Application No: AW/299/24/HH

Site Address: 8 Cherry Close Aldwick PO21 3BA

Description of works: Demolition of the existing porch and detached garage. New rear/side flat roof extension, front porch extension. Conversion of the first floor roof space with new front and rear dormers. Installation of 2 x side windows.

Thank you for your internet representation made on 17th January 2025 which has been recorded as an objection with the comments as follows:

PROPOSED ELEVATIONS

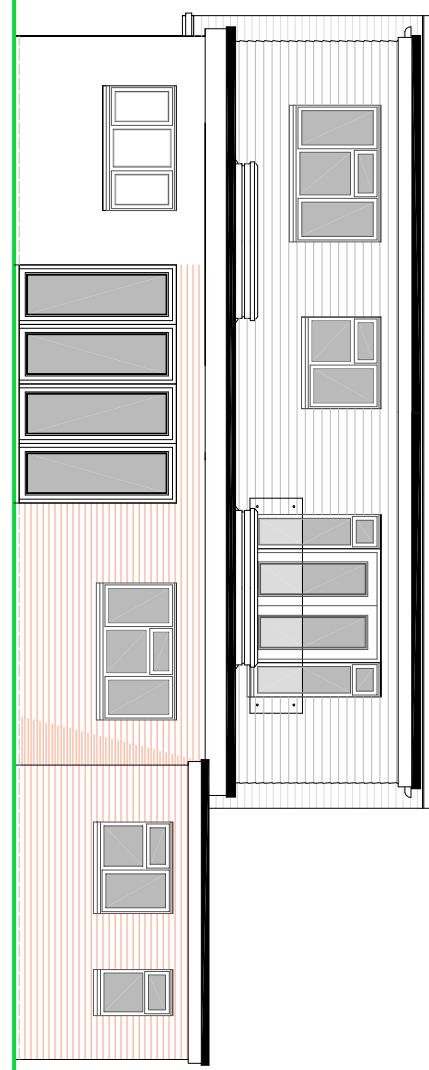
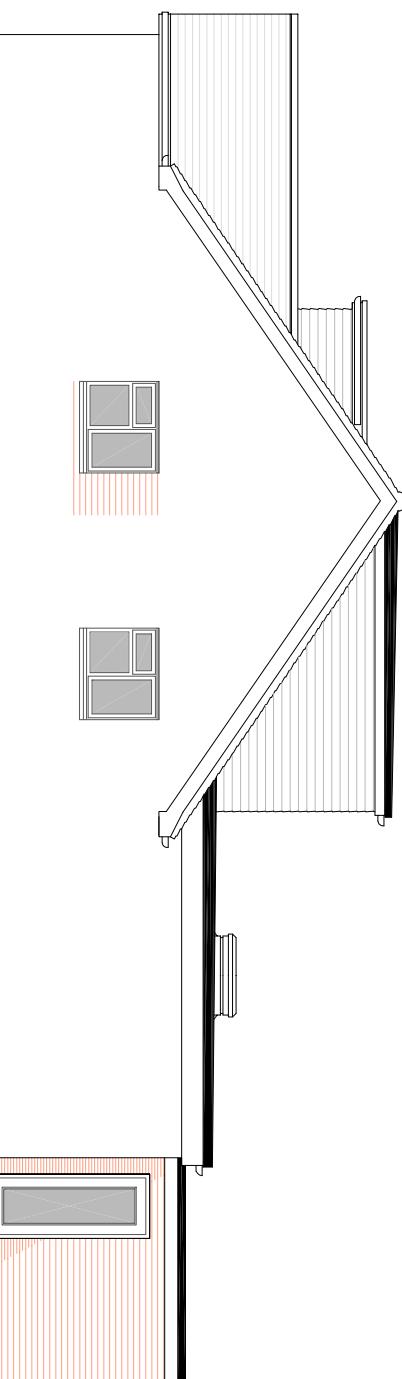
Mark change of front elevation of property regarding dorma windows and flat roof visible from front. Breach of planning rules.

Rear first floor building intrusive to our back garden.

Excessive size out of keeping with Close.
